**KIRKLEES METROPOLITAN COUNCIL
INVESTMENT & REGENERATION SERVICE**

DELEGATED DECISION TO DETERMINE PLANNING APPLICATIONS

Reference No:	2023/62/90349/E
Site Address:	adj, 11, Park View, Cleckheaton, BD19 3AN
Description:	Erection of detached dwelling
Recommending Officer:	Nina Sayers

DECISION - REFUSED

Site Plan 1:100

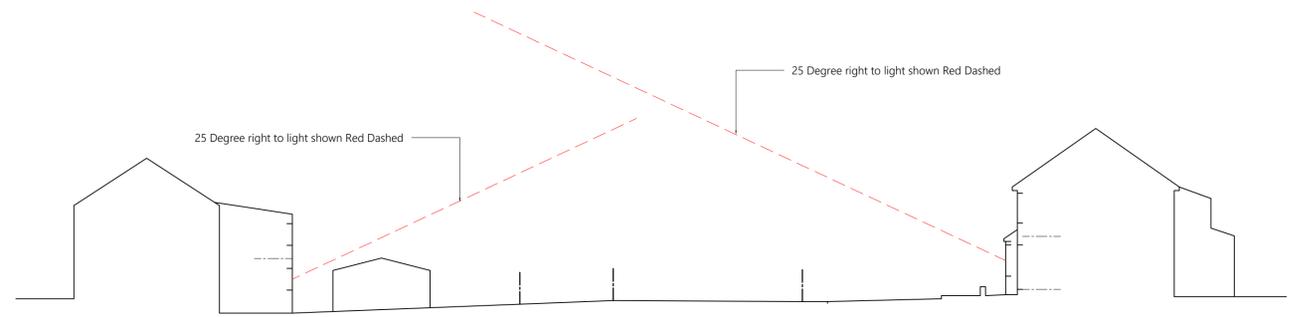
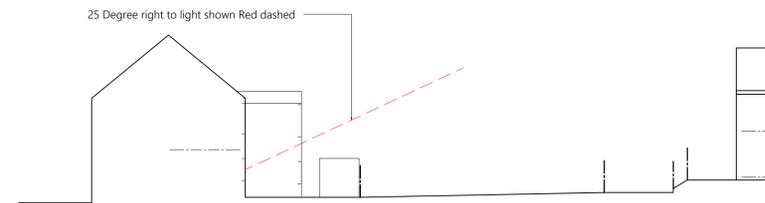
1. The constraints arising from the size and shape of the plot are insufficient to suitably accommodate a new dwelling. A dwelling on this site would result in a cramped form of development that would fail to sympathetically integrate with existing development in the locality, which would be detrimental to the visual amenity of the wider street scene. The proposal therefore fails to comply with LP24 (a) of the Kirklees Local Plan, Principles 2, and 4 of the Housebuilders Design Guide Supplementary Planning Document and Chapter 12 of the National Planning Policy Framework

2. The siting and scale of the proposed development would have an overbearing and overshadowing impact on the occupants of nos.13 and 15 Park View and the limited amenity space which they have to the rear of their properties, to the detriment of residential amenity. The proposal therefore fails to comply with Policy LP24 (b) of the Kirklees Local Plan, Principle 6 of the Housebuilders Design Guide Supplementary Planning Document and Chapter 12 of the National Planning Policy Framework.

Job No	Drawing No	Rev
1356	211

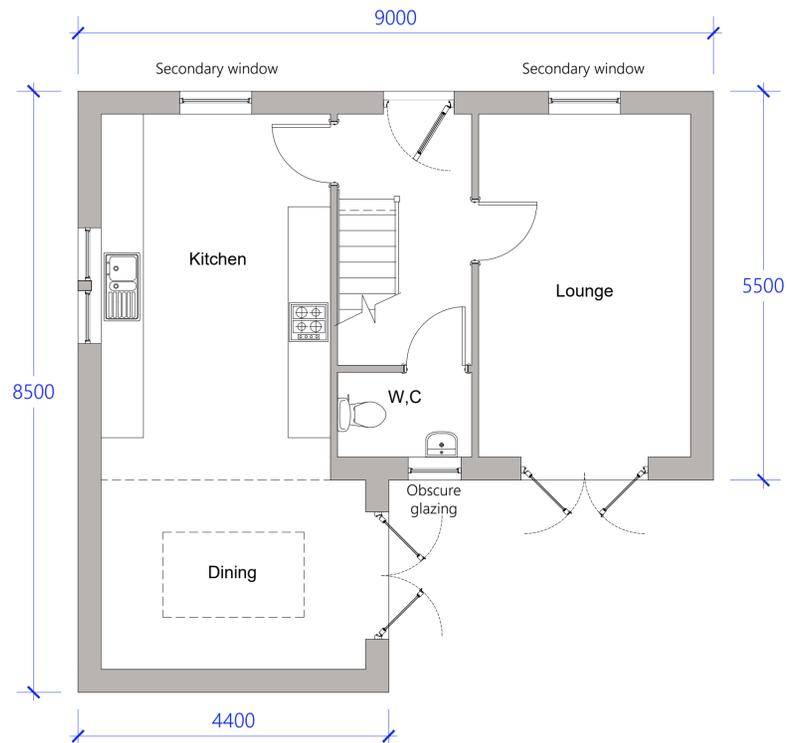
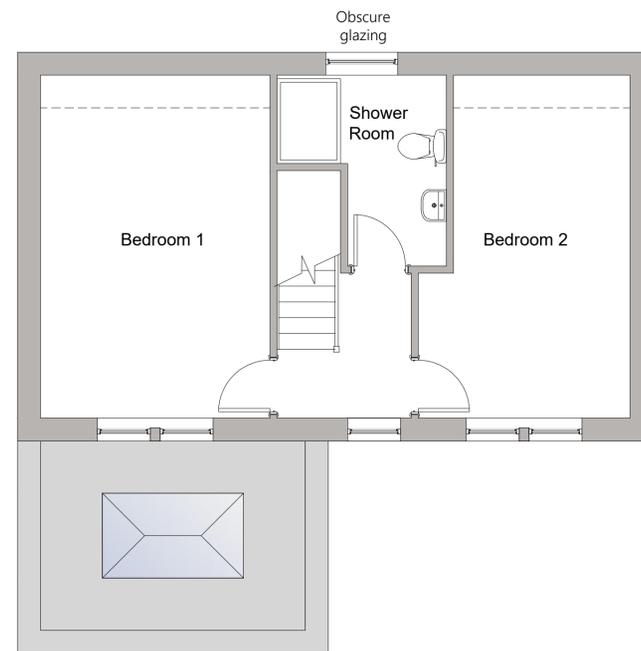
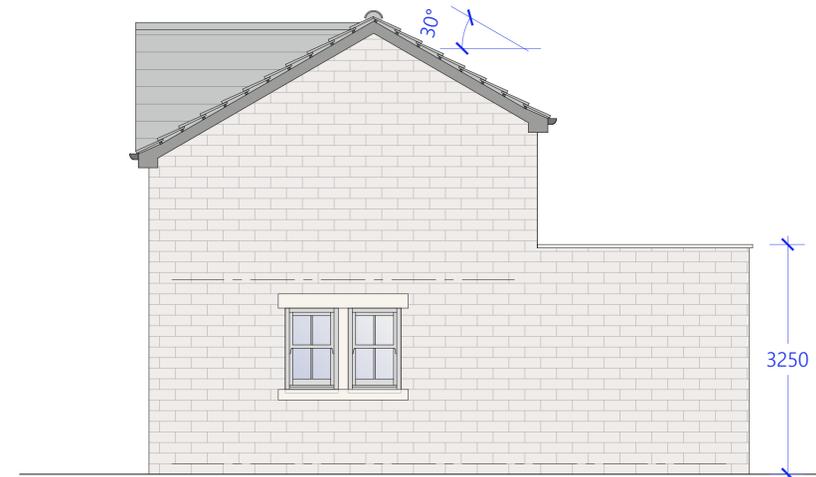
1. The use of obscure glazing on the principal elevation would fail to address the street positively, appearing incongruous in design and detrimental to visual amenity of the wider street scene. The proposal therefore fails to comply with LP24 (a) of the Kirklees Local Plan, Principle 14 of the Housebuilders Design Guide Supplementary Planning Document and Chapter 12 of the National Planning Policy Framework.
